From: Simon Davis <Simon.Davis@arun.gov.uk>
Sent: 21 July 2021 14:20
To: Planning.Responses <Planning.Responses@arun.gov.uk>
Subject: FW: Y/76/21/DOC Condition 5 Flint Walls

Further Conservation Officer Consultation Response

Development	YAPTON		
Location	NORTH_END_ROAD_YAPTON		
Marketing Name			
Drawing Title	LOW_FLINT_WALL		
Drawing Number	783-DET-002		
Revision	-	Scale @ A1	1:10_&_1:200
Drawn By	SK	Date Started	24.05.2021
Checked by		Date

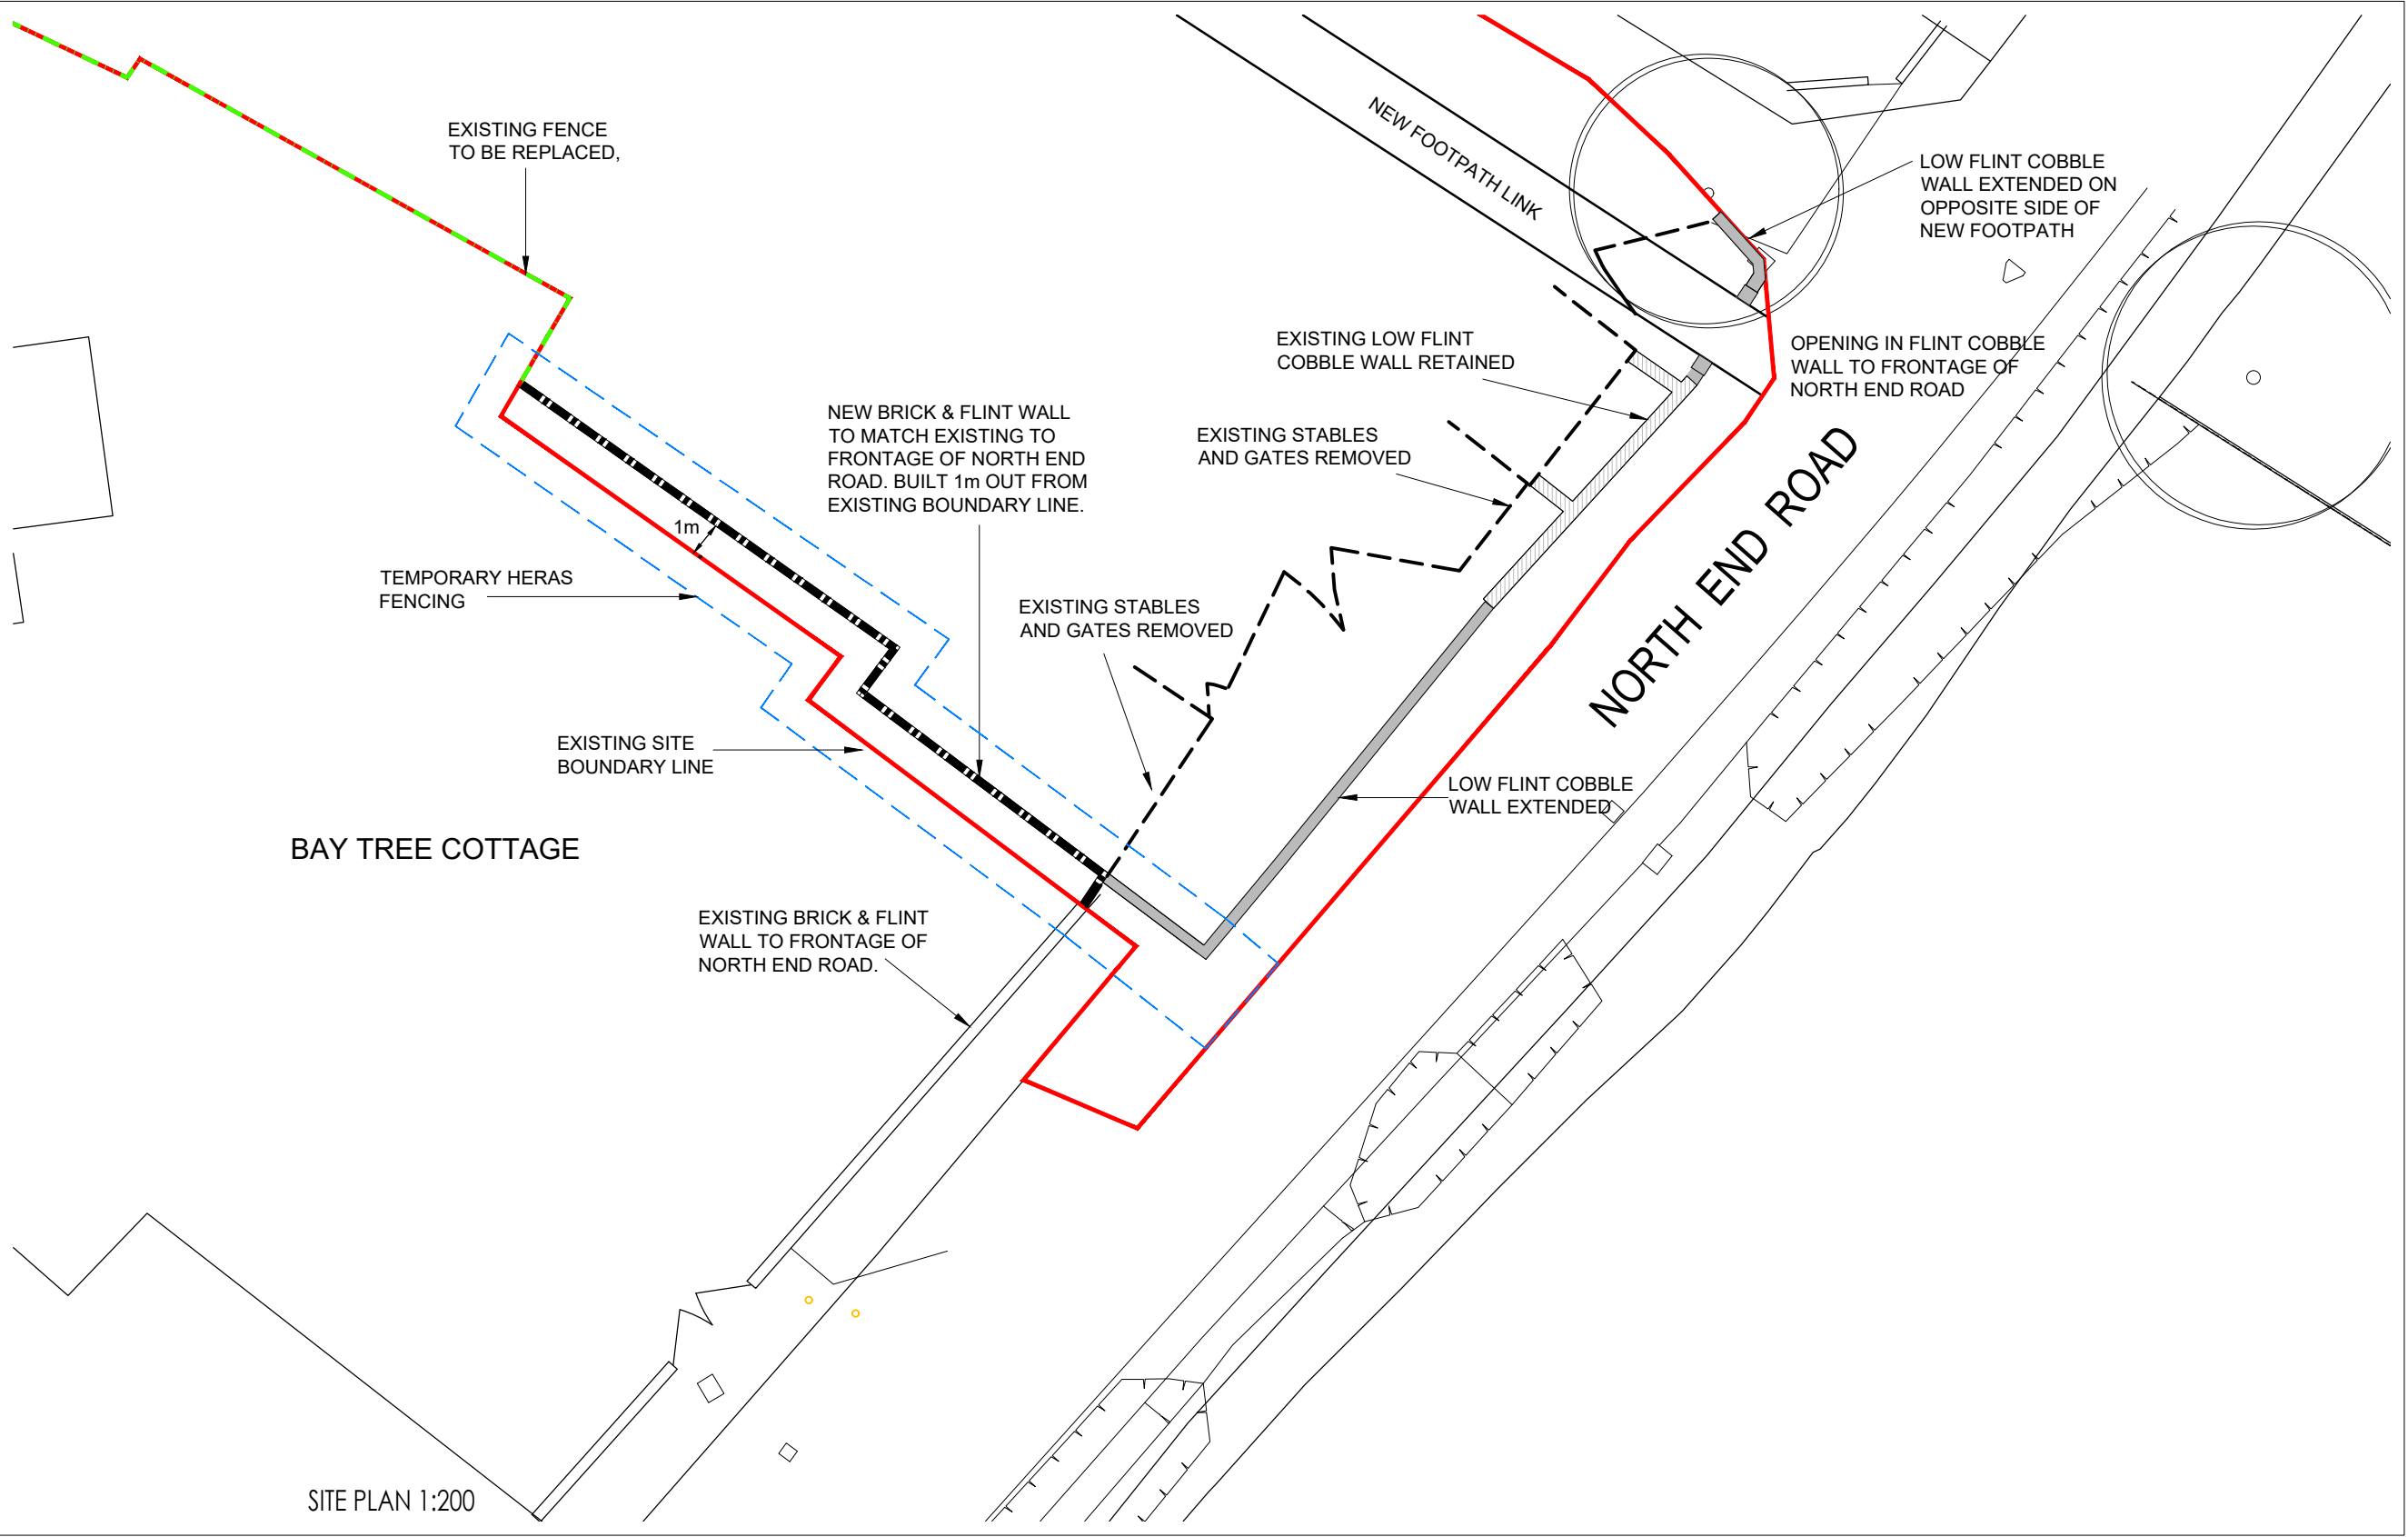
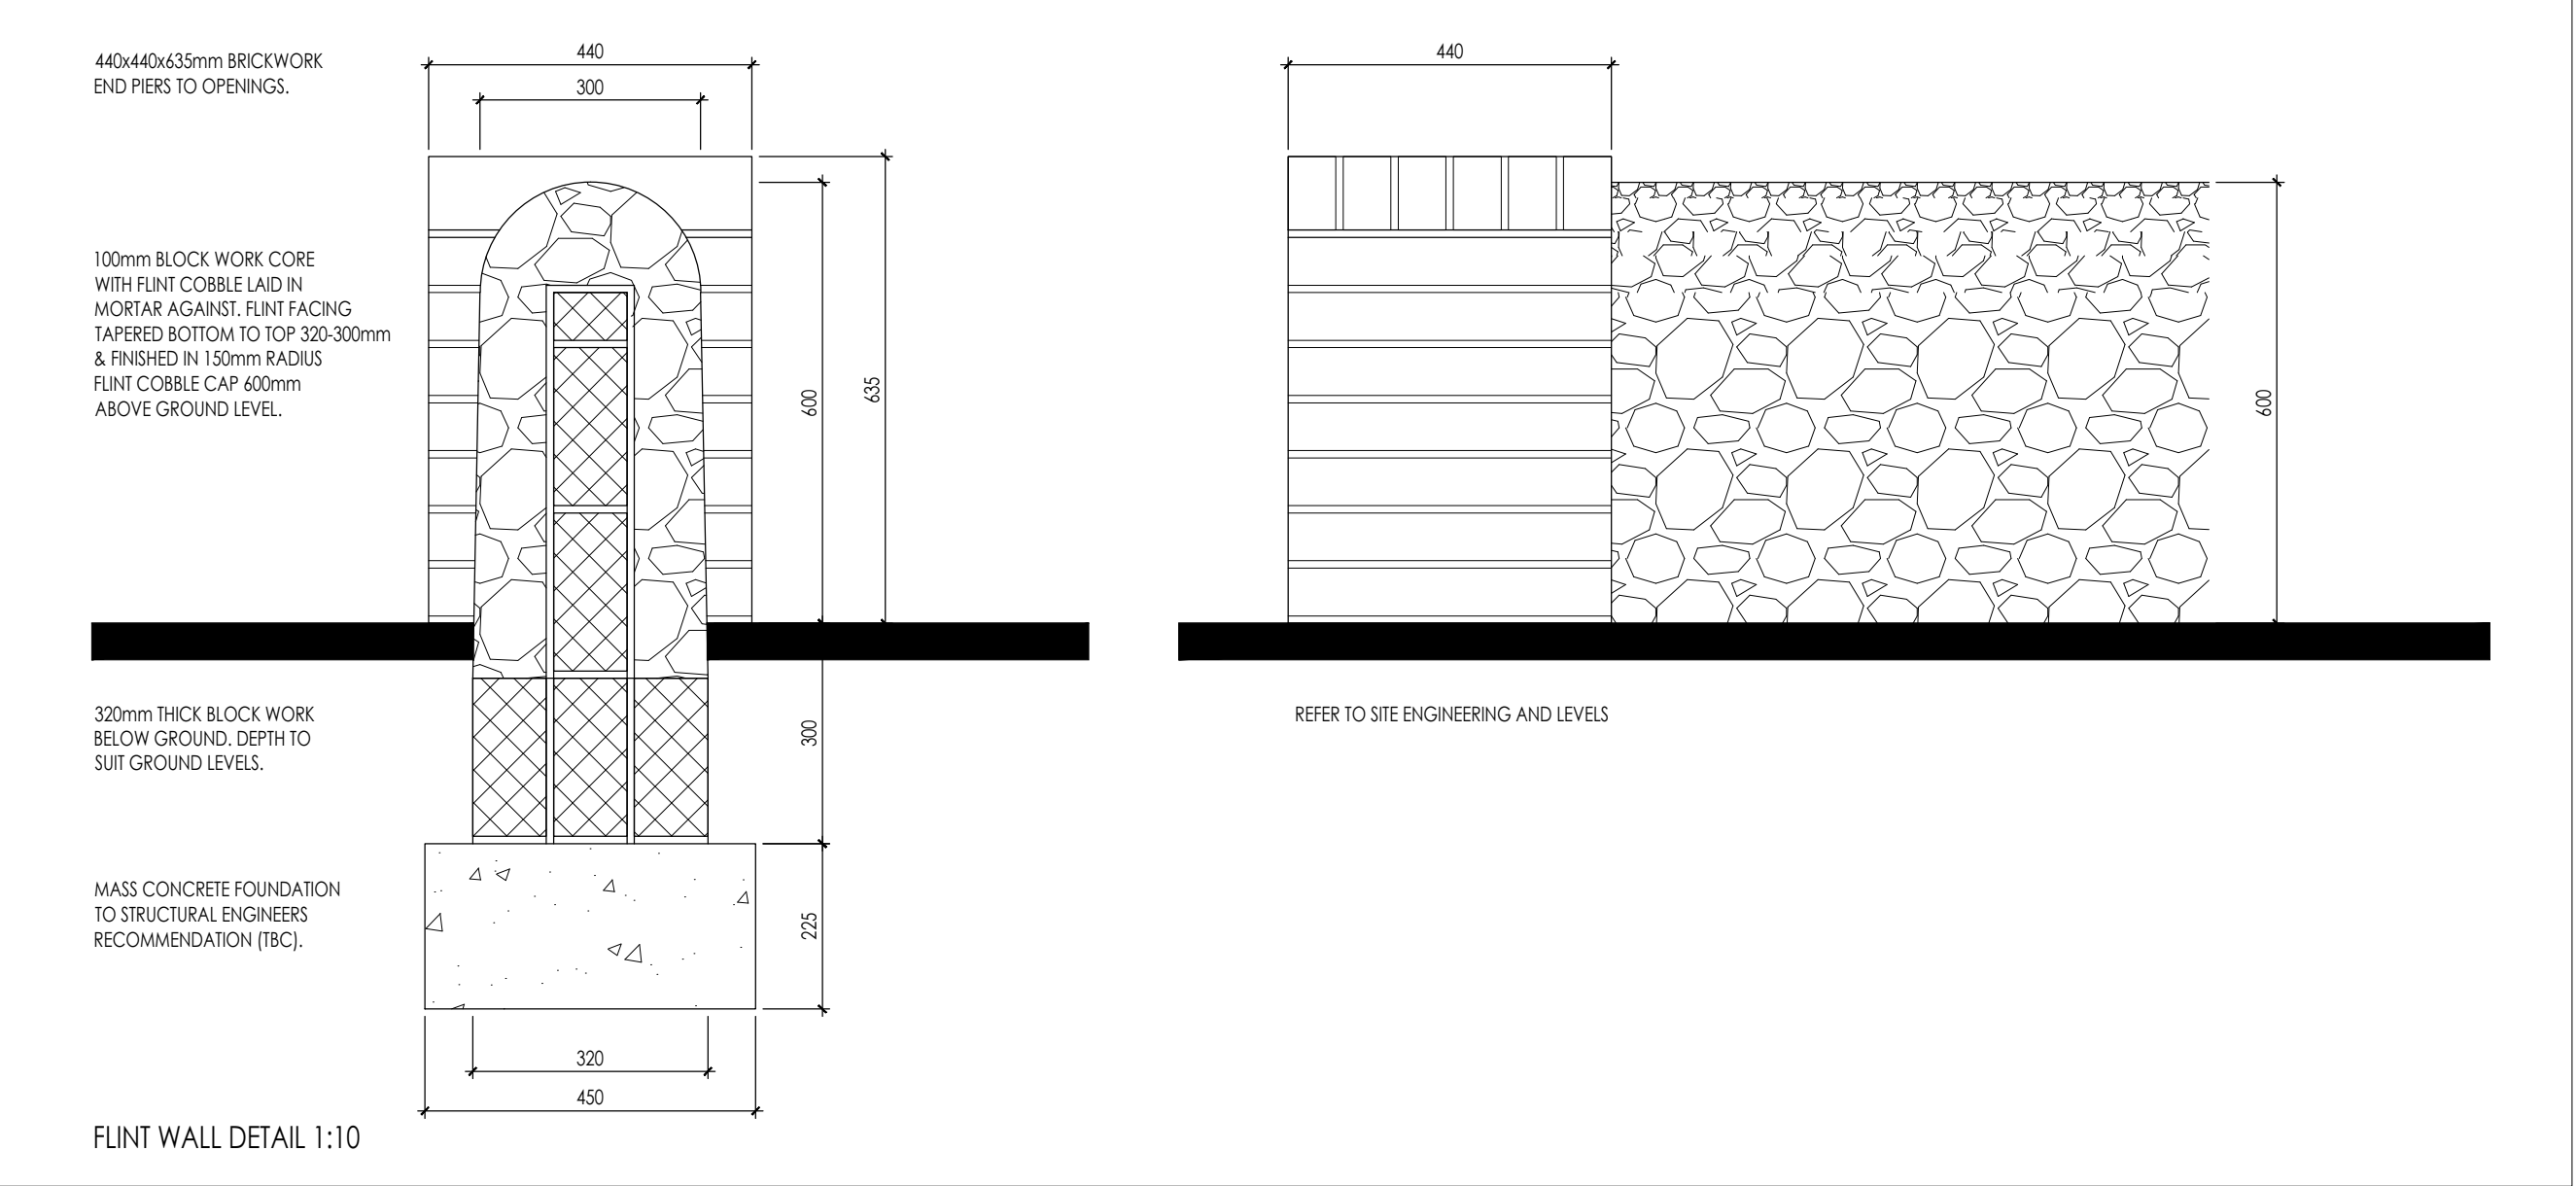
"The design of the flint wall seems to be generally acceptable and appears to replicate the existing wall. However, it is not clear how the southern end of the new section of flint walling will connect back to the neighbouring walling. At present, it looks as though the new section of wall terminates in front of, but not connected to, the neighbouring flint wall. Is this correct. If so, it will leave a section without any walling. Please can this be clarified."

Simon,
The alternative approach as suggested by the applicant (of reducing the length and tying it into the existing wall) seems a logical and acceptable approach to me
Martyn

The alternative is the wall is reduced in length and ties into the existing wall (see extract below).
